8th February 2021

Application No: LU/349/20/HH
Site Address: 32 & 33 Mariners Quay Littlehampton BN17 5DA
Description of works: Extension of rear balconies. This application affects the character & appearance of the Littlehampton (River Road) Conservation Area.

OWPC33560

Proposed Elevations

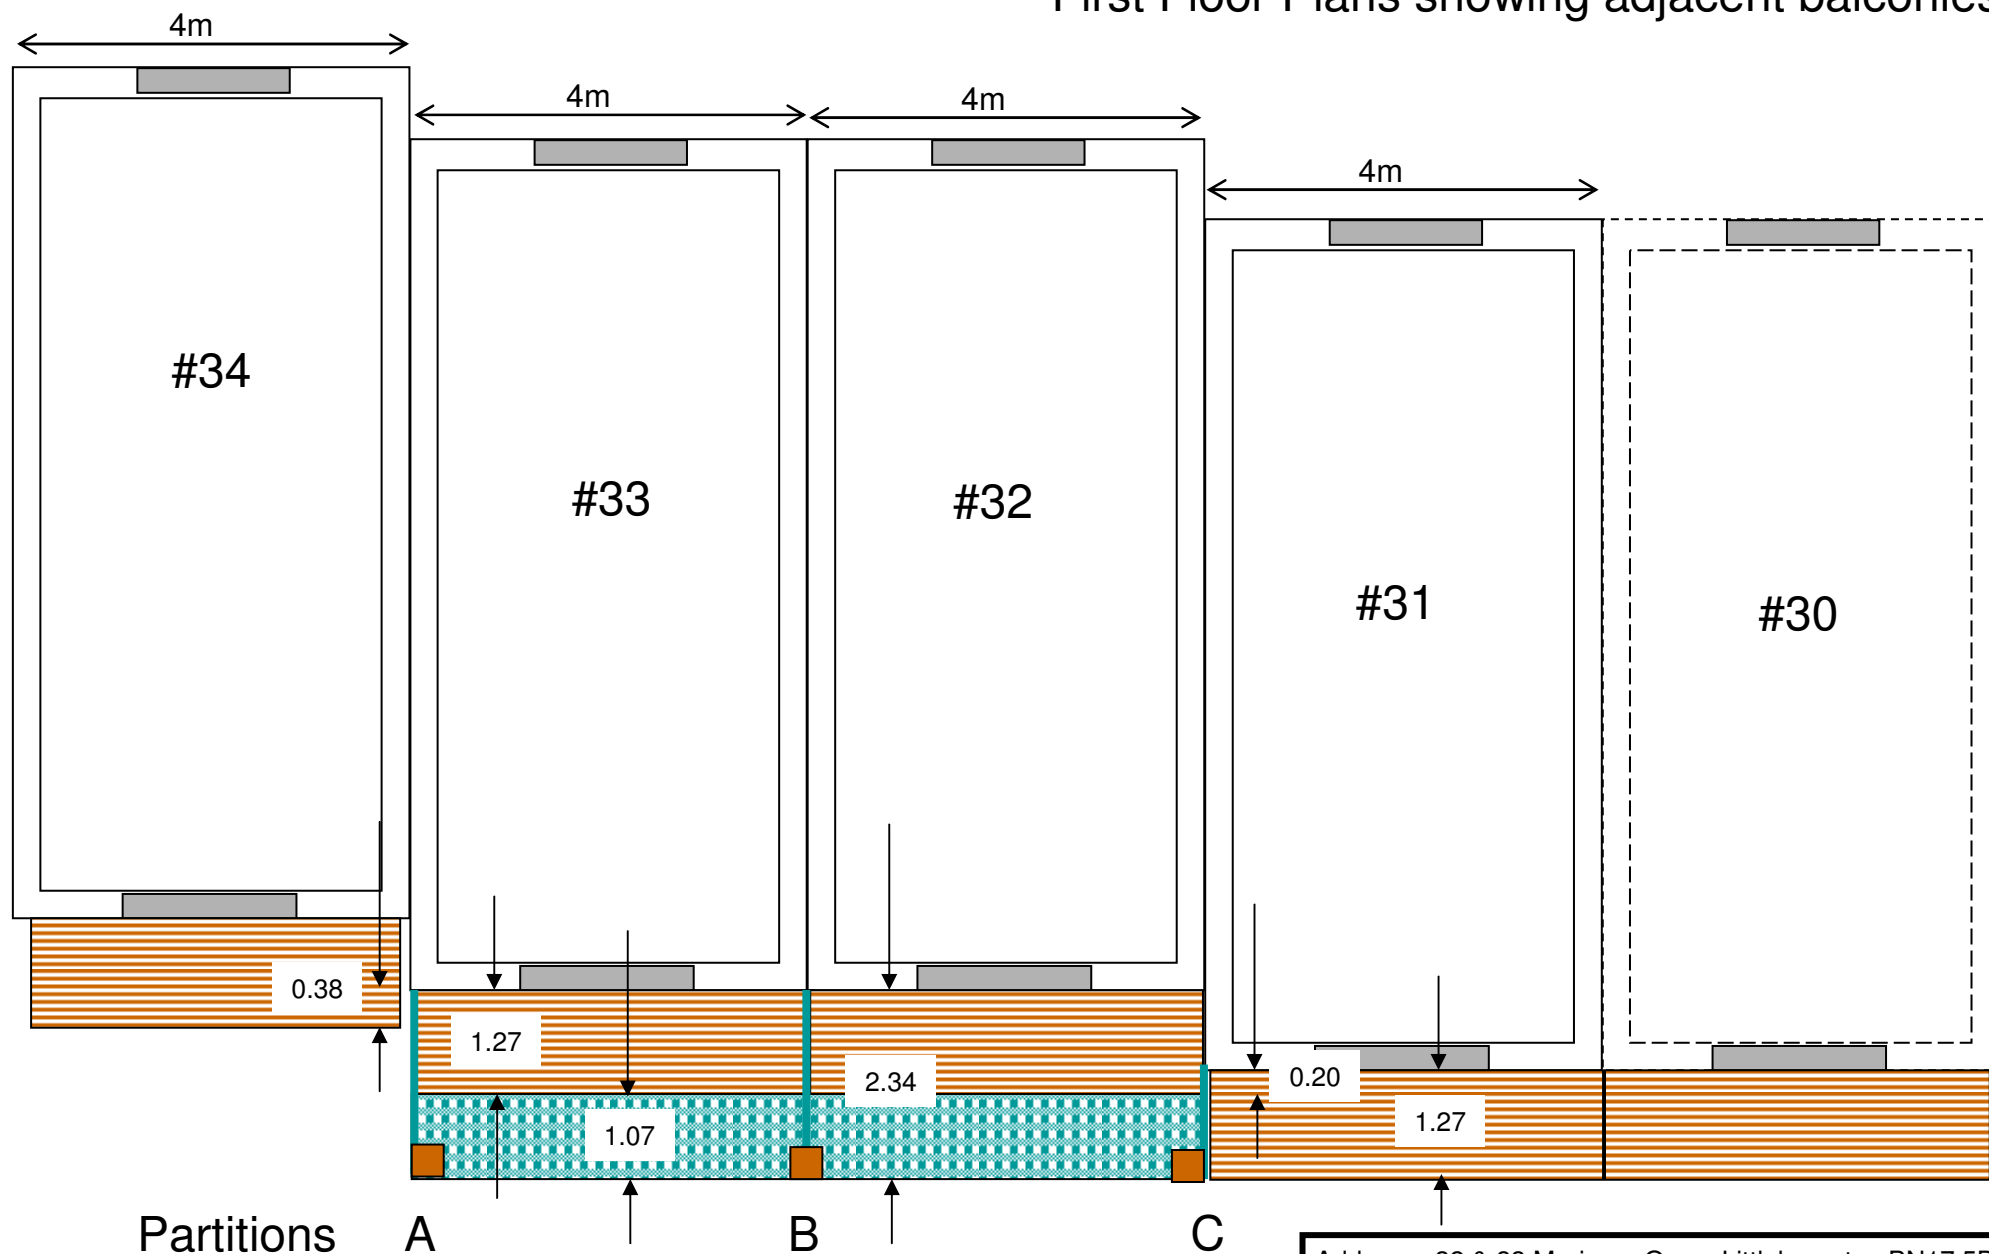
Nos 30-31 are distinctive in the terrace in having a painted render facade, rather than brickwork, and a very prominent gable. The breaks in plane either end of this facade and in the balcony area provide particularly pleasing and well mannered proportions to this section of the terrace. The proposal to extend the balcony in the same plane across the frontage of nos 32-33 will severely compromise and detract from these attractive proportions to the detriment of the appearance of Mariners Quay and the conservation area. The situation will be made even more incongruous with the introduction of the supporting stanchions which are not a feature of the terrace. In addition, any grant of planning permission will set a precedent for similar proposals in the remainder of the terrace leading to further detrimental effects.
